From: Martyn White <Martyn.White@arun.gov.uk>
Sent: 01 May 2020 10:57
To: Planning.Responses <Planning.Responses@arun.gov.uk>
Subject: AB/26/20/PL

AB/26/20/PL

5 The Old Slipway River Road Arundel BN18 9EY

New balcony

DRAWING
Second Floor Plan + Elevations
as Proposed

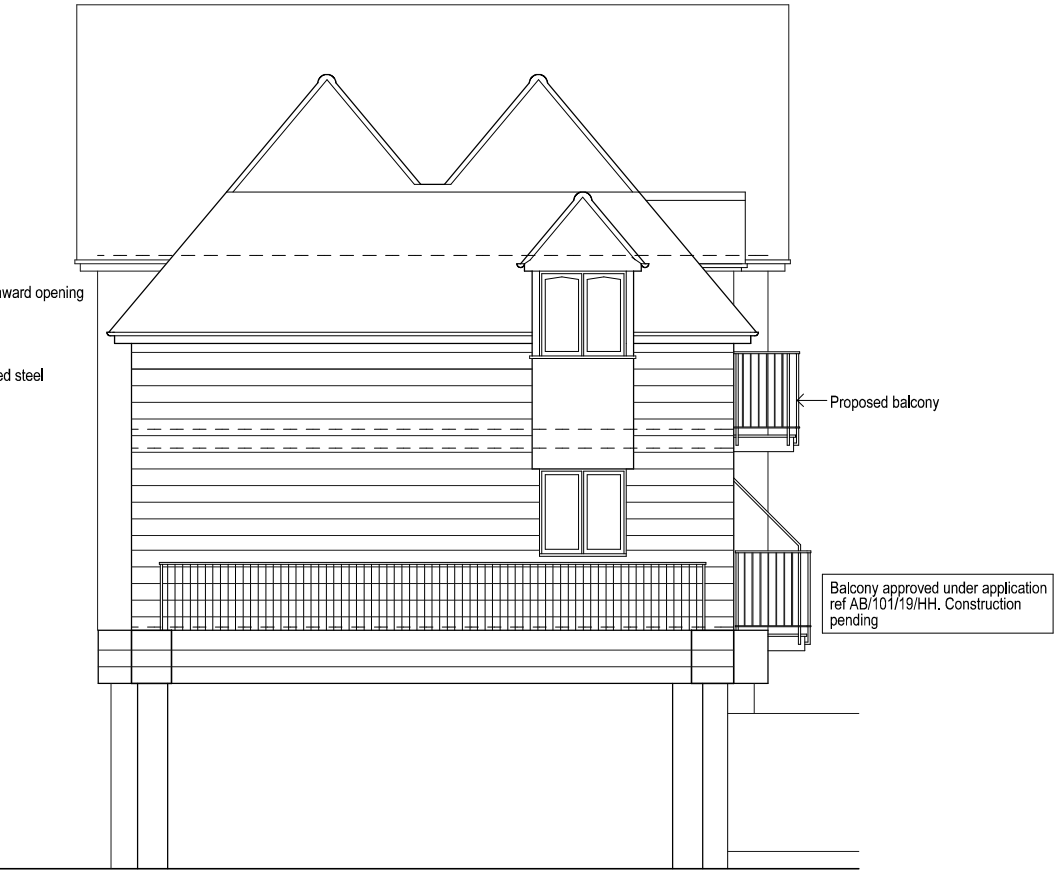
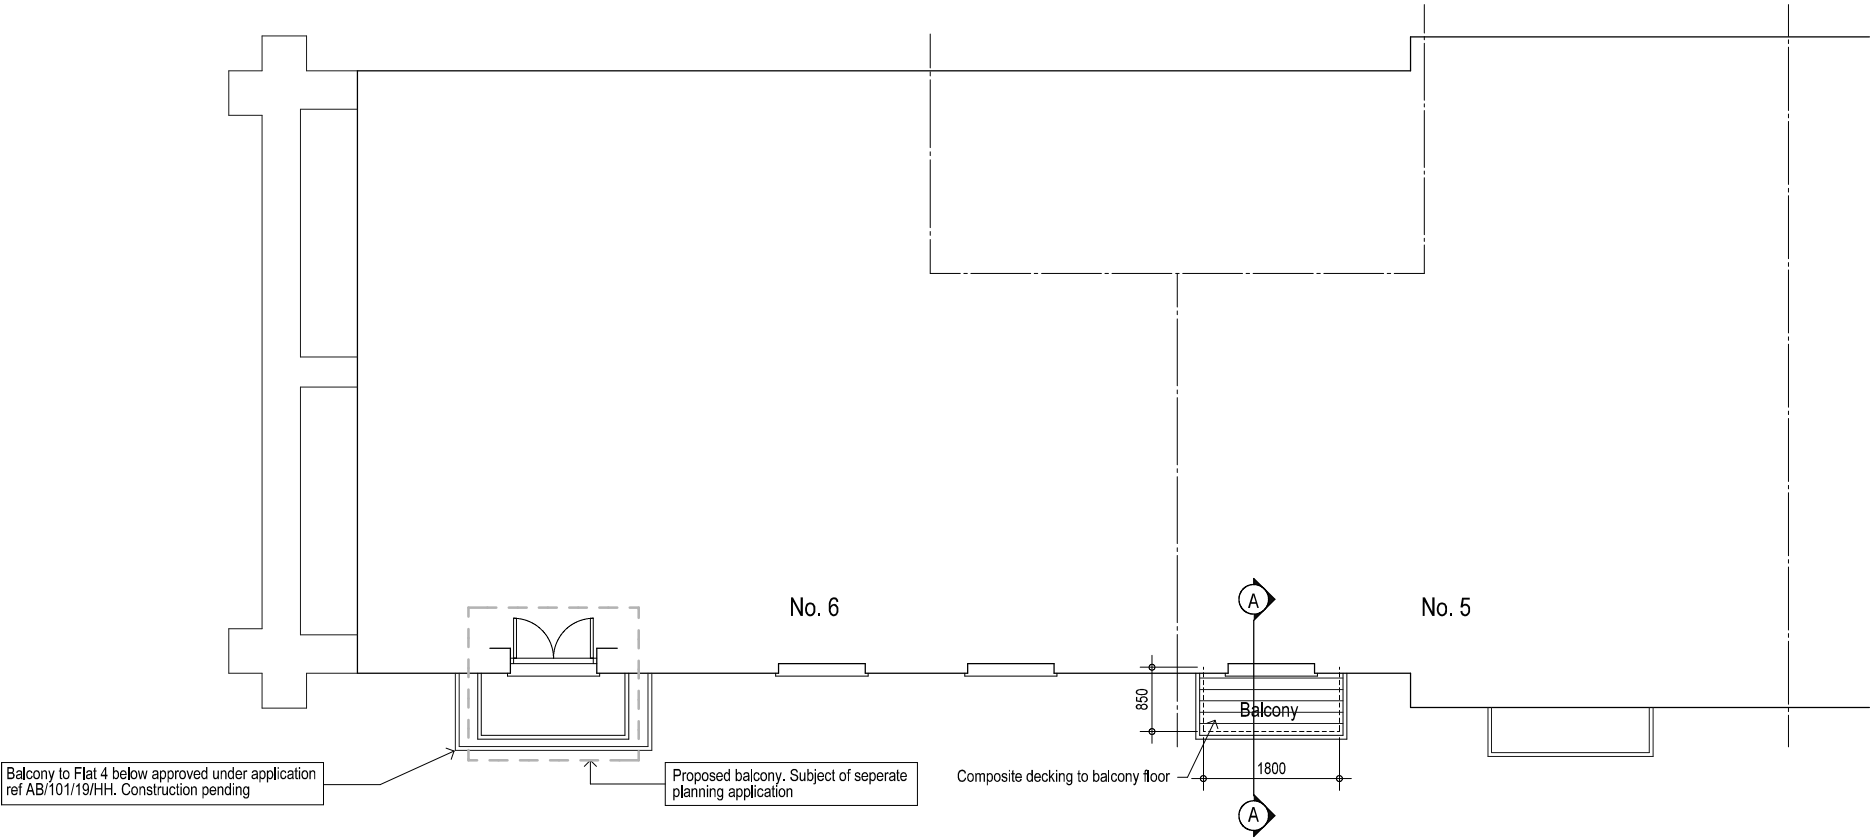
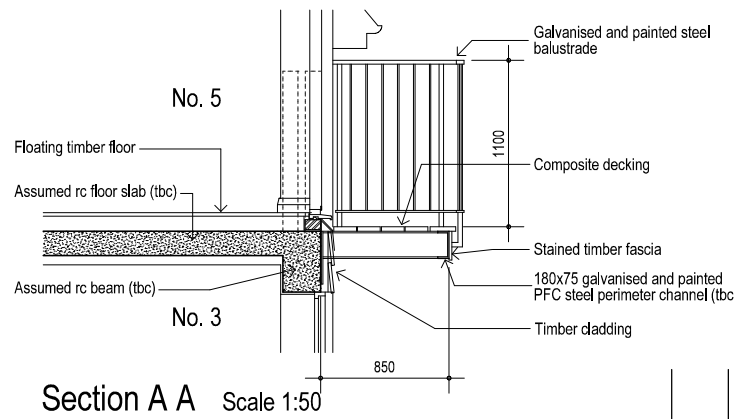
The proposal is to remove an existing south facing window and install inward opening French doors. A galvanised and painted steel balcony will be fixed to the face of the building.

It is considered that the proposal is of a scale which will not harm the appearance of the building or the character of the local area. The new French Window should match the existing joinery in terms of appearance, and colour. Likewise, the balcony should also be the same colour as those already present.

It is noted that there is also a separate application for the same proposal in another apartment within the building. When considered together the proposals will maintain the symmetry of the façade, and it would be preferable if they were implemented at the same time.
